August 24, 2018

Re: MMC Staff Parking Garage | 222 St. John Street | Level III Site Plan
Response to Public Comments 2

TYPICAL HYDRANT ASSEMBLY DETAIL
N.T.S.

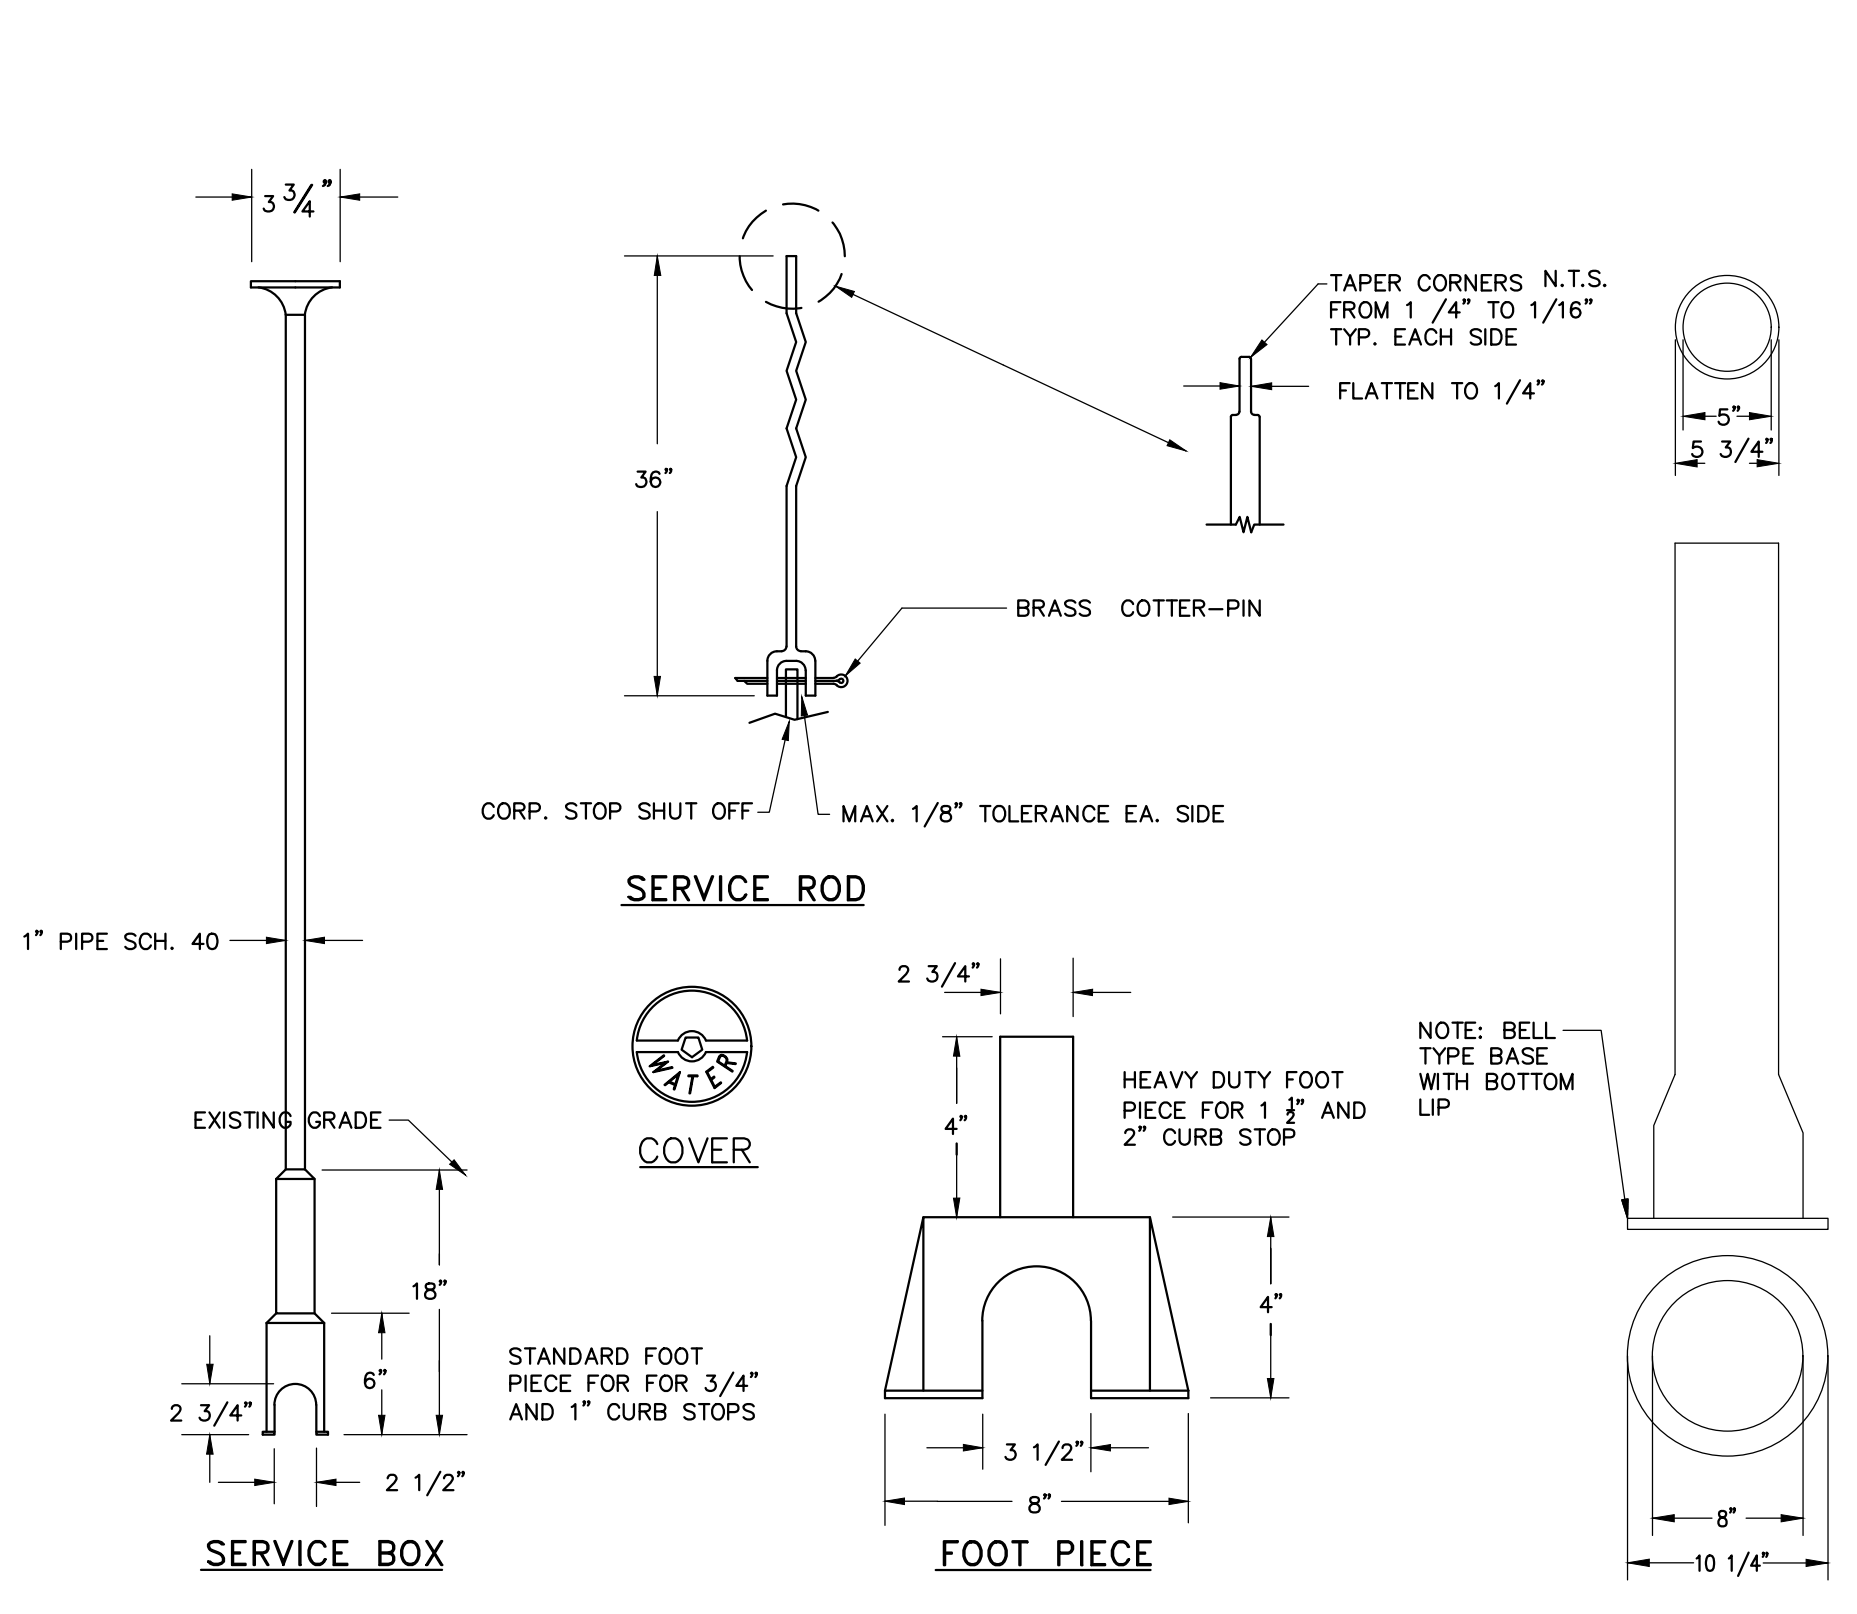
1. *The only item that still is of concern is the location of the private hydrant. We'd like to have it moved further west, between the access road into the lower garage entrance and surface parking lot. The proposed location doesn't give us easy access for operations covering the majority of the building.*

Response: The enclosed plans depict a revised hydrant location as recommended by the Fire Department.

GRADING & DRAINAGE PLAN - 2

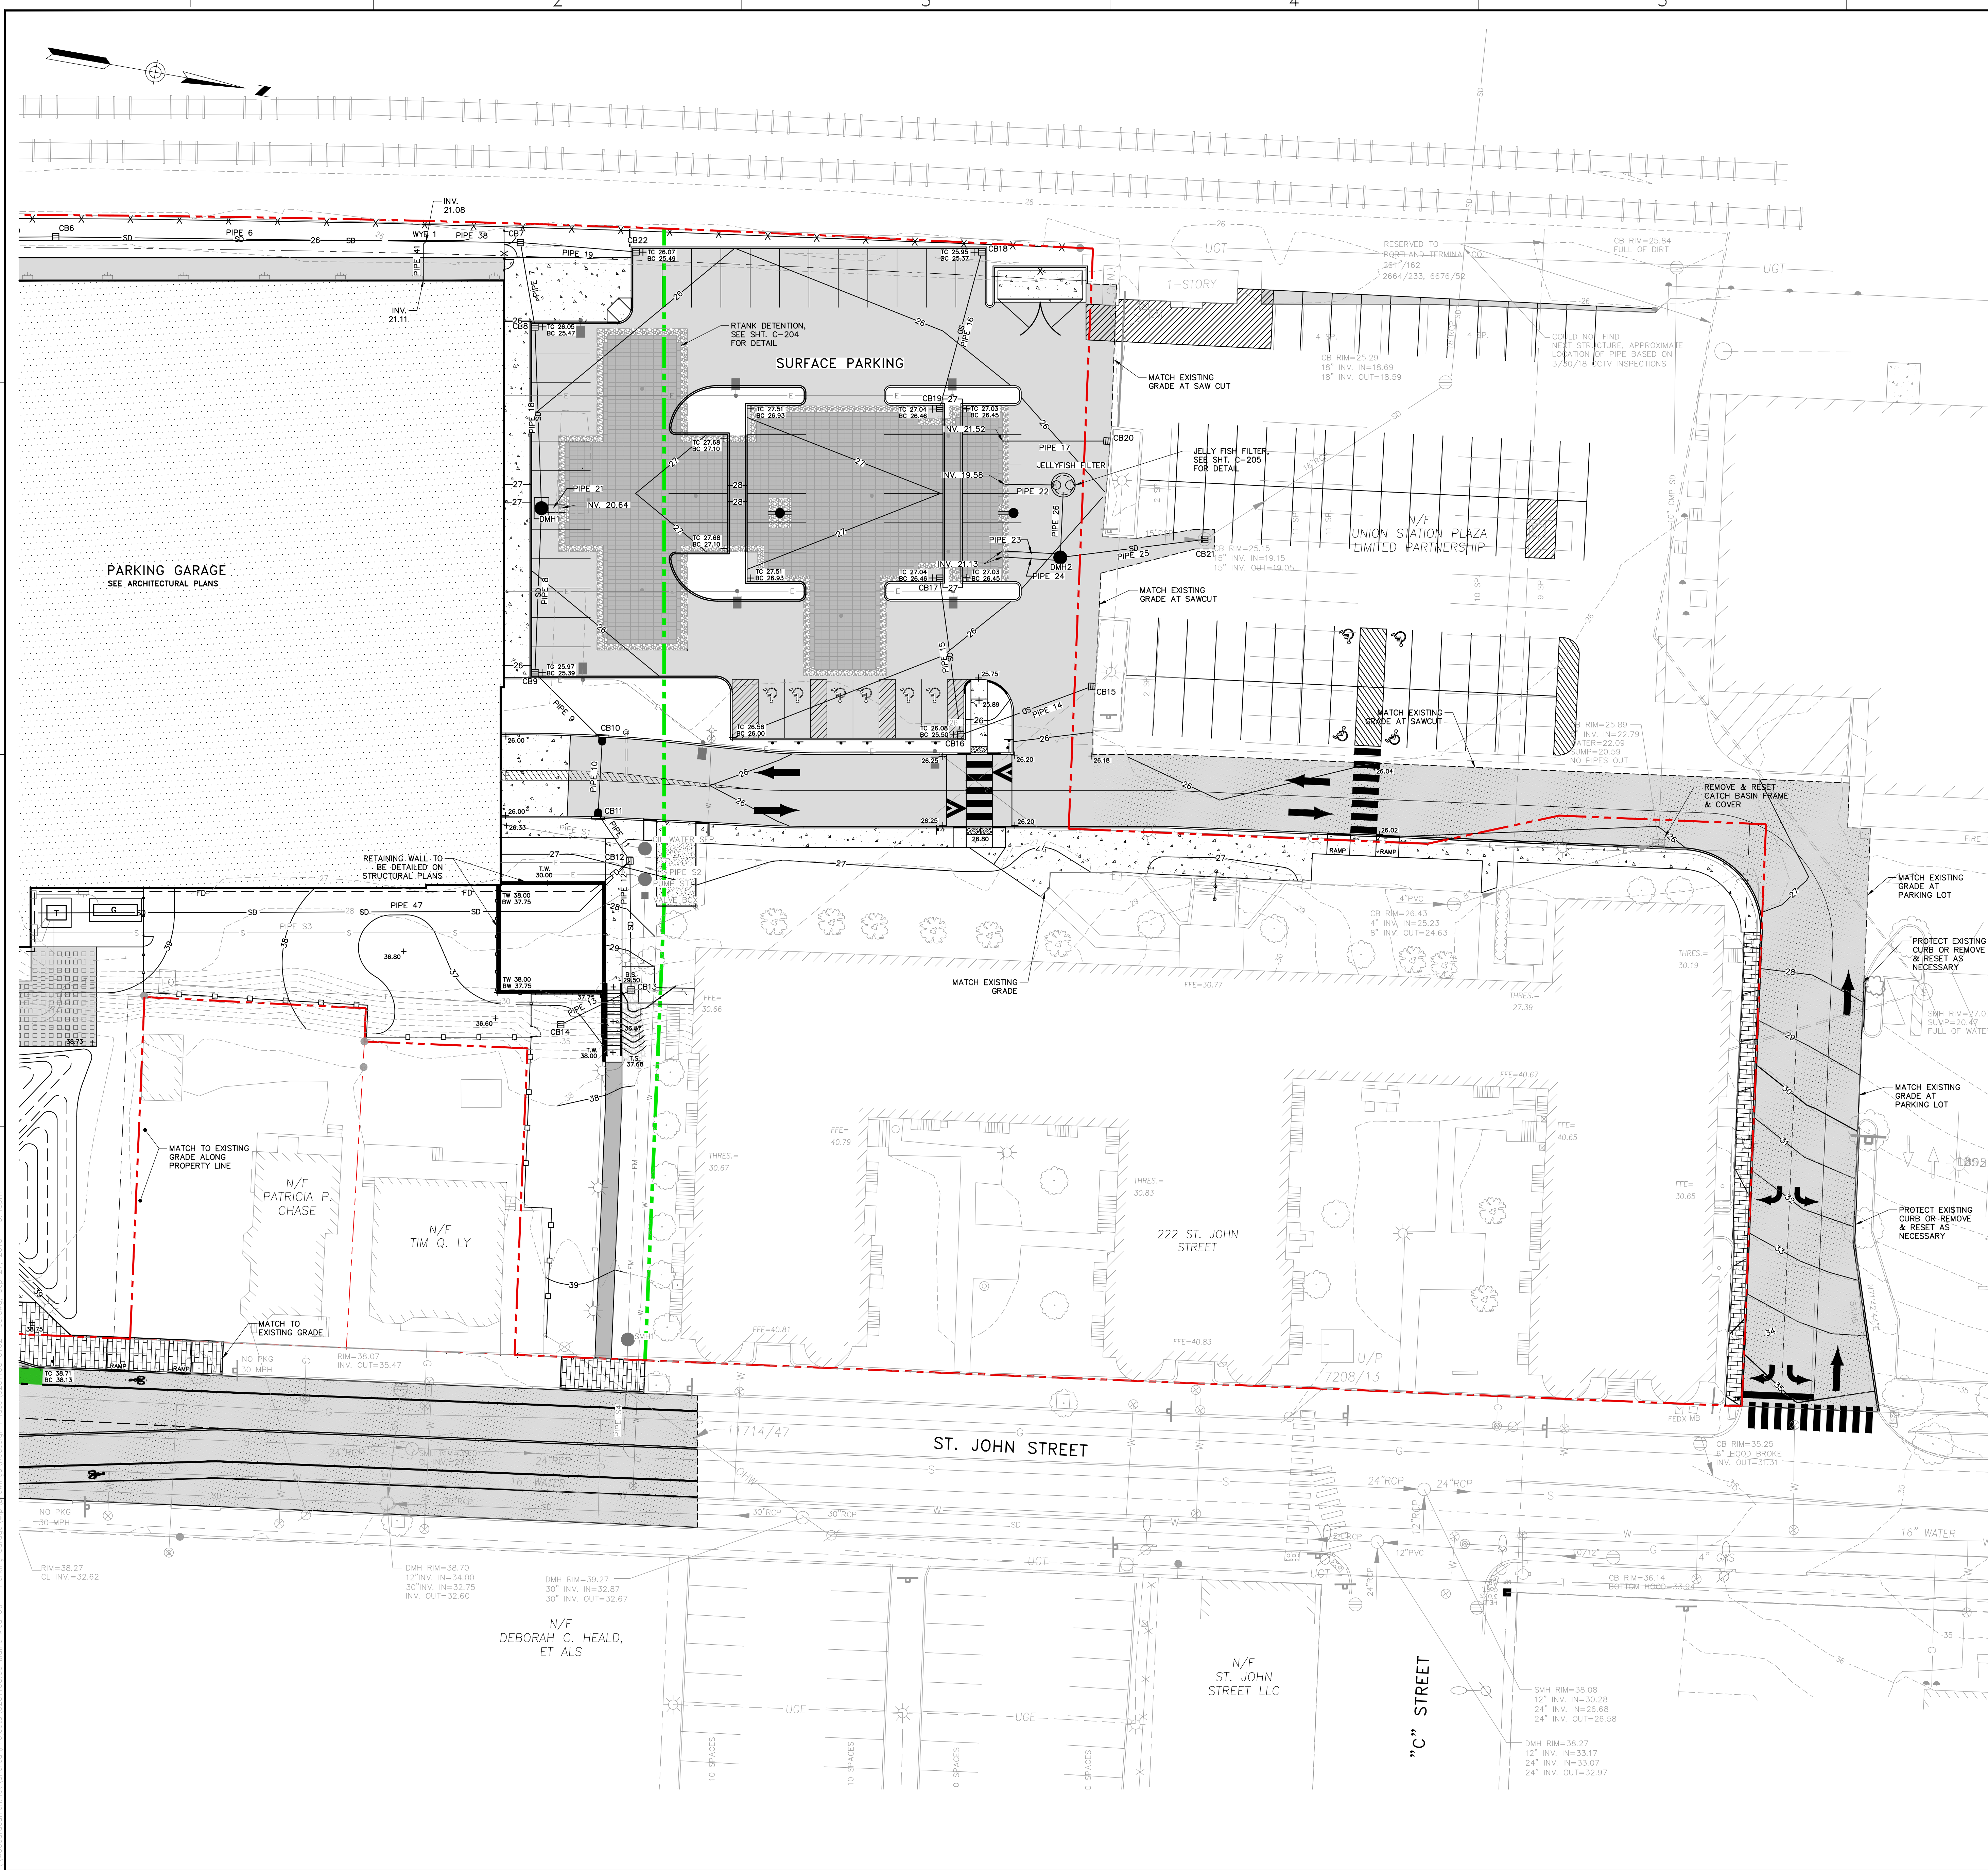
b. *Grading review identified that Pipe 14 between CB15-CB16 has a negative slope. Please revise or provide explanation.*

c. *Top of curb and Bottom of Curb information at CB-18 appears to be inverted. Please revise or provide explanation.*

Response: The pipe slope and associated invert elevations have been modified in the attached, revised plans.

Response: These elevations has been modified in the attached, revised plans.
